Planning Services Sign Permit Review Form

Date of Submittal	Application Number	Applicant	Landowner
7/3/2024	SIGN2407-0001	Limitless Lawns	Brayden Preserve Developers LLC

Contact Person	Contact Number
Jared Shea	919-414-2755
Sign Location	PIN Number
NW Corner of Moore Union Church Rd. and future Borne Dr.	0600-57-0572.000

Front View

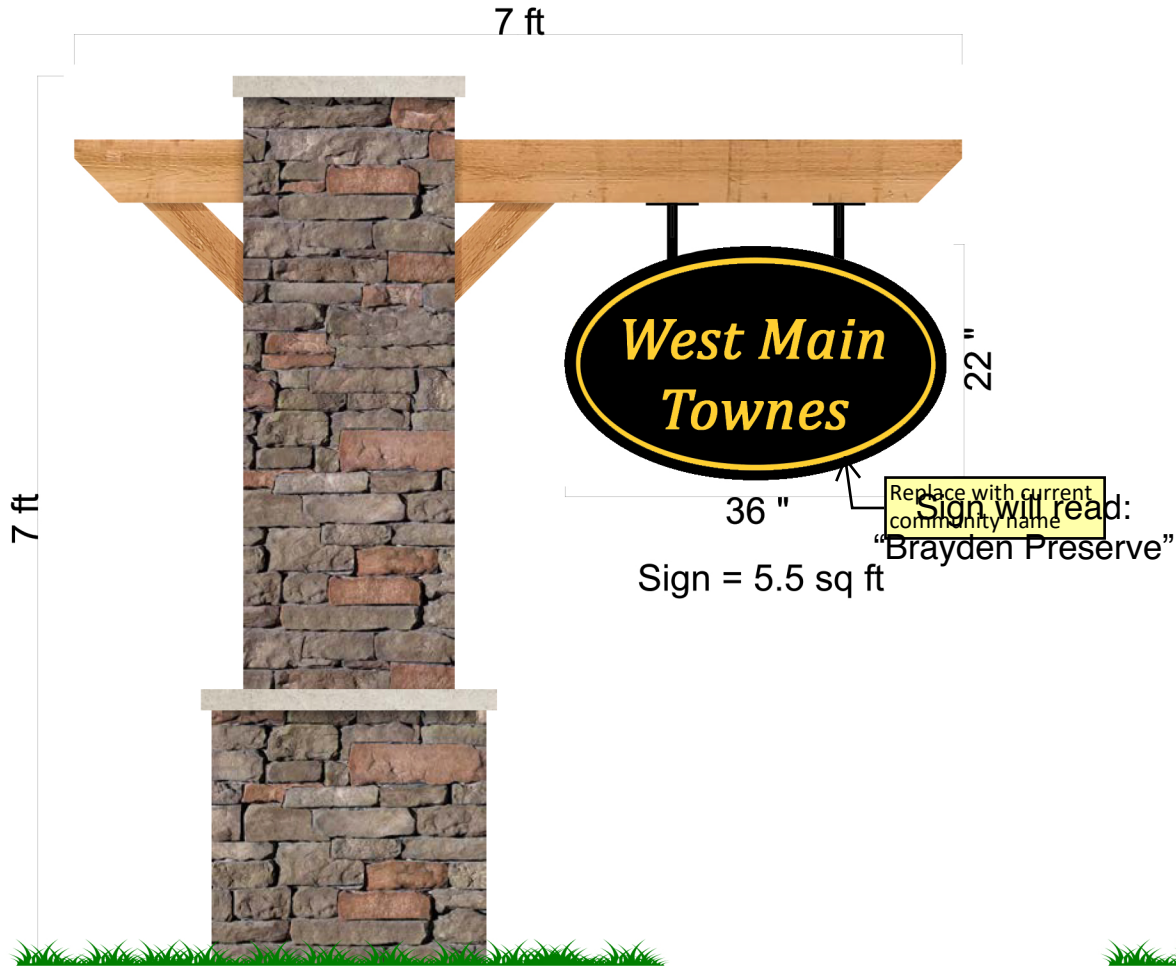
Comments	-Sign exceeds the maximum allowable height of 6'. -No setbacks are provided on the site plan. Please indicate the setbacks from the sign to each property line and ROW.
----------	--
